CITY OF ALBUQUERQUE

June 2, 2023

Re: Rise & Roast TI
9160 Coors Blvd. NW
Traffic Circulation Layout
Architect's Stamp 05-12-23 (C13-D007)

SITE PLAN

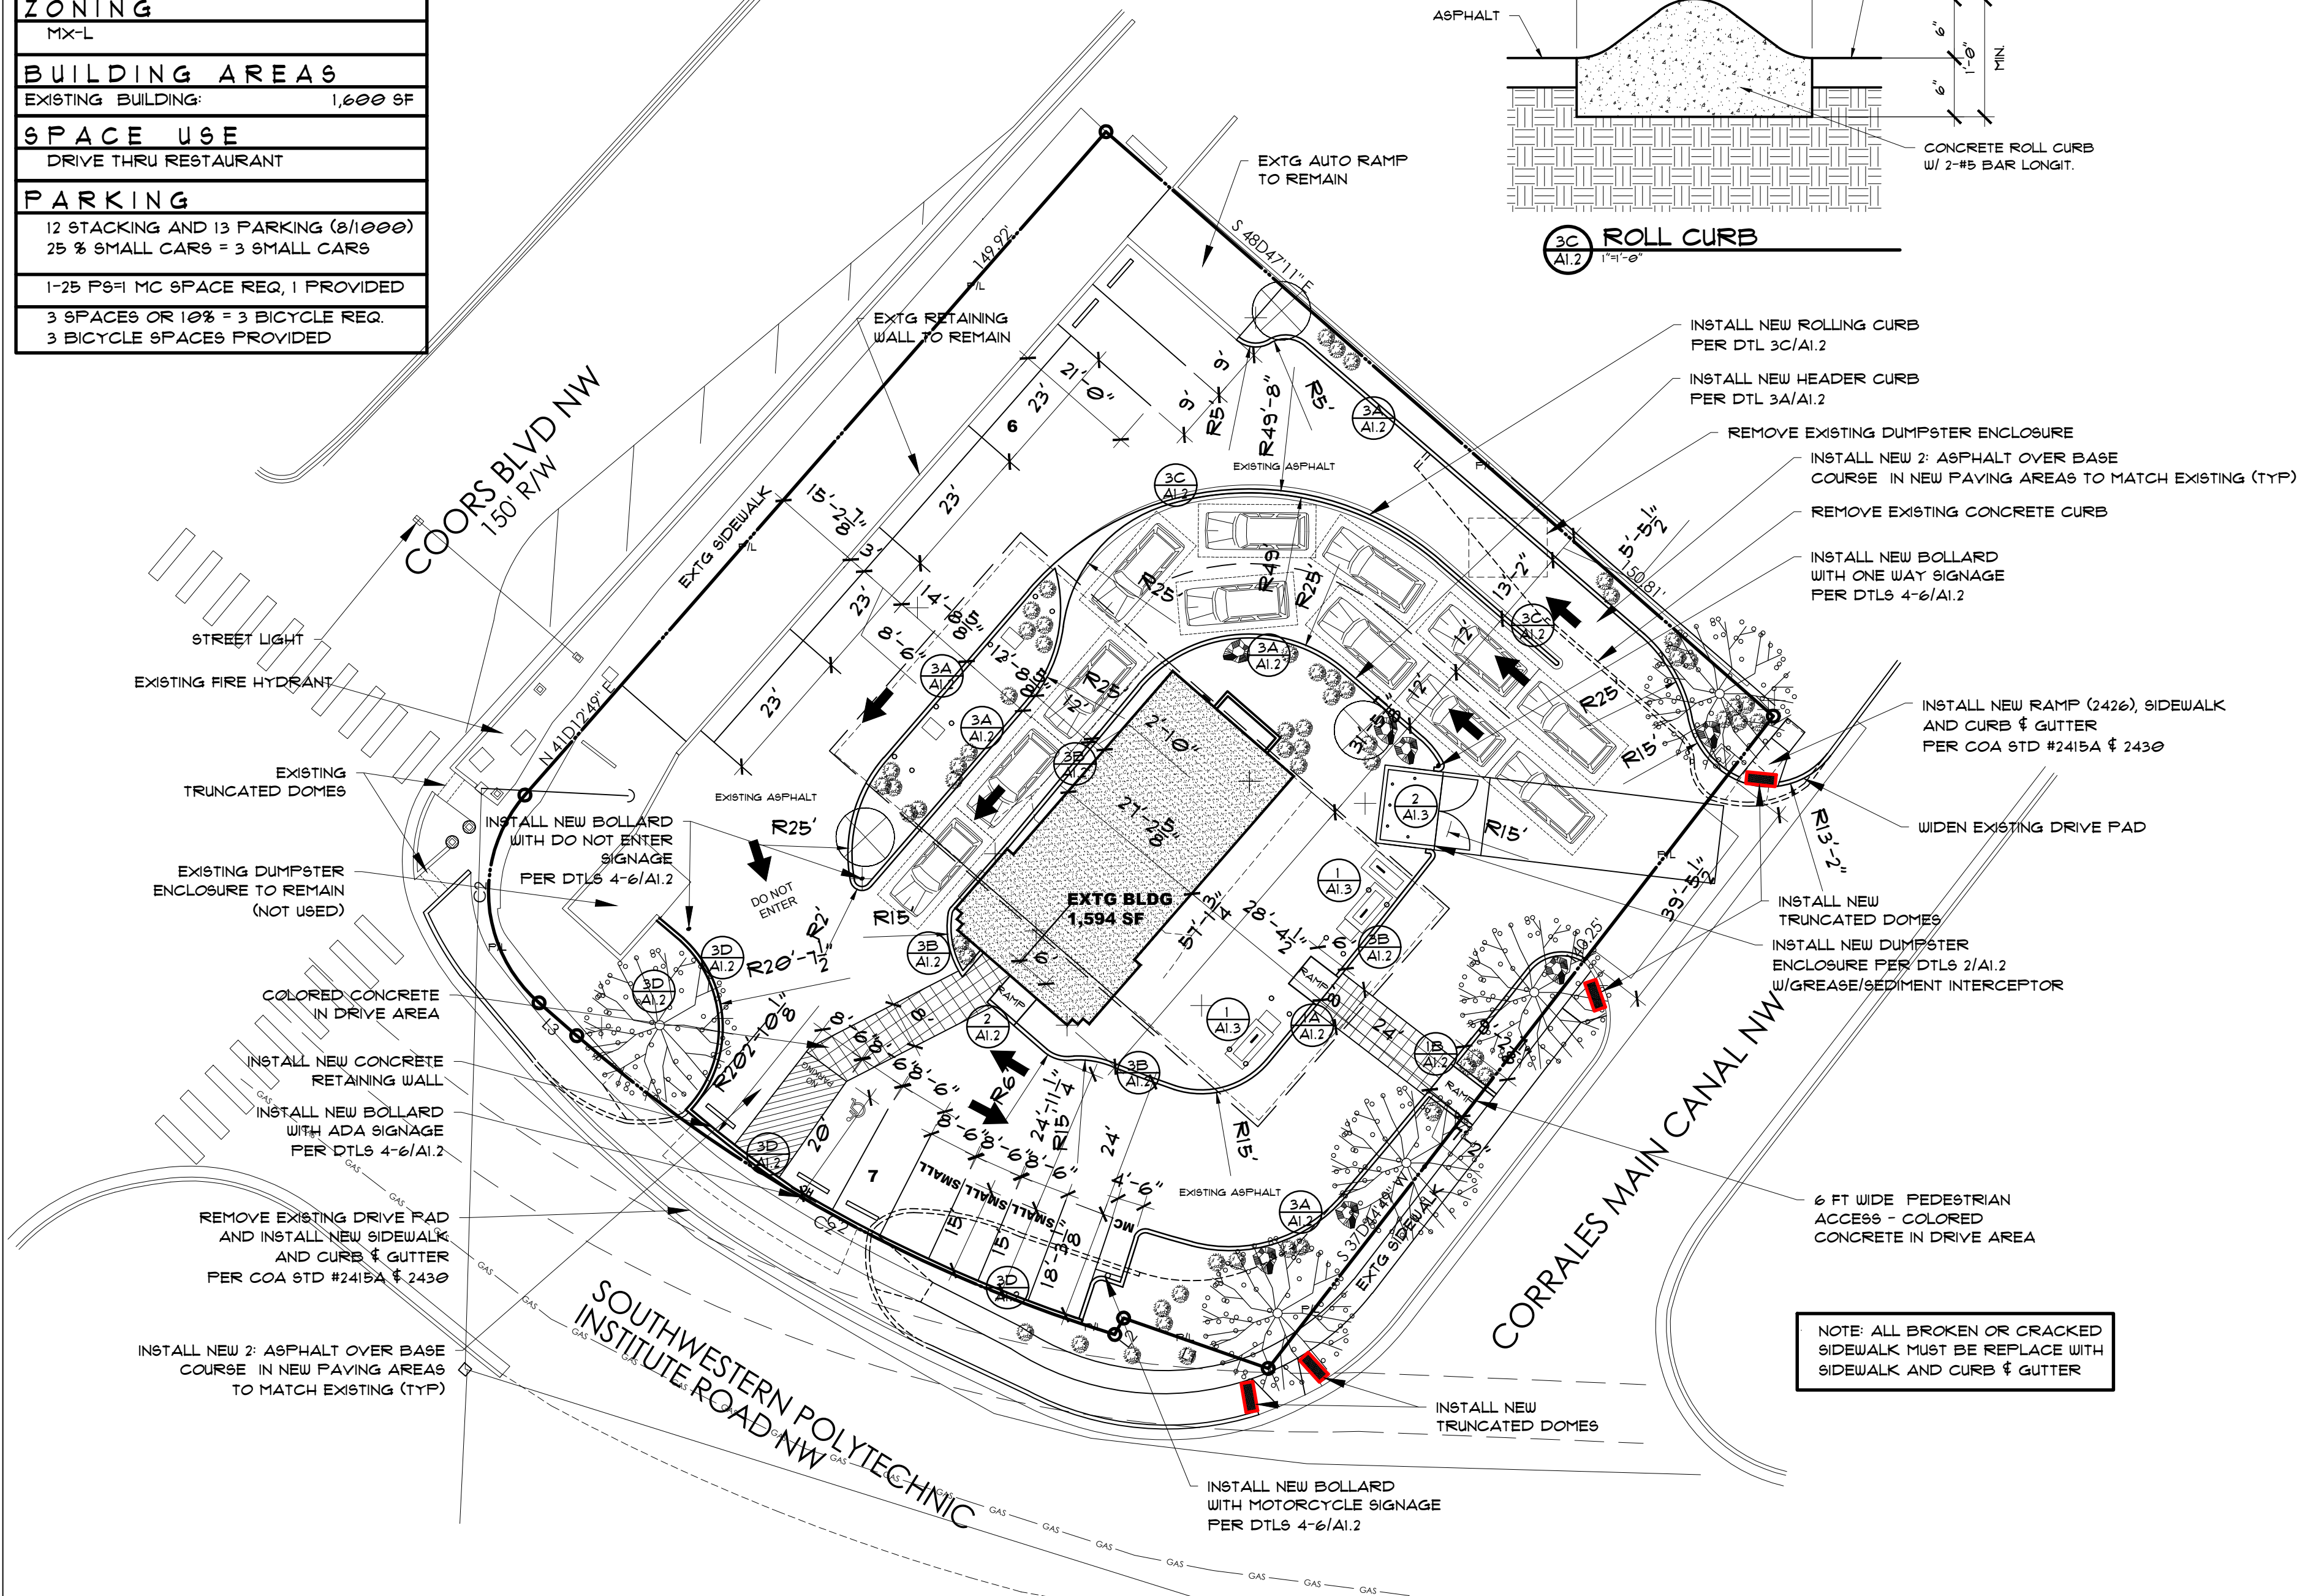
1. Identify all existing access easements and rights of way width dimensions.
2. Identify the right of way width, medians, curb cuts, and street widths on Coors Blvd., Southwestern Polytechnic Rd. and Canal Frontage.
3. List the number of Motorcycle and Bicycle parking spaces required by the IDO.
4. Please provide "ONE WAY" sign and pavement marking at the beginning of the drive-thru.

5. Site access must be updated to current standard and have Truncated Domes installed.
6. ADA curb ramp at the corner of Southwestern Polytechnic Rd. and Canal Frontage Rd. must be updated to current standards and have truncated domes installed.
7. Provide the proposed interior ramps details.

8. Please show on the site plan the 6' wide ADA pathway from the ADA aisle to the building entrance.

9. Please remove Refuse Enclosure details from TCL sheet.
10. Provide a copy of Solid Waste and Fire Marshal approval.
11. It is not apparent what type of pavement surface is being proposed. A hard driving surface will be required as part of this proposed project for parking area and drive aisles.

12. Show the clear sight triangle and add the following note to the plan: "Landscaping and signage will not interfere with clear sight requirements. Therefore, signs, walls, trees, and shrubbery between 3 and 8 feet tall (as measured from the gutter pan) will not be acceptable in the clear sight triangle."

13. Please specify the City Standard Drawing Number when applicable.
14. Add a note stating "All broken or cracked sidewalk must be replaced with sidewalk and curb & gutter." A build note must be provided referring to the appropriate City Standard drawing.
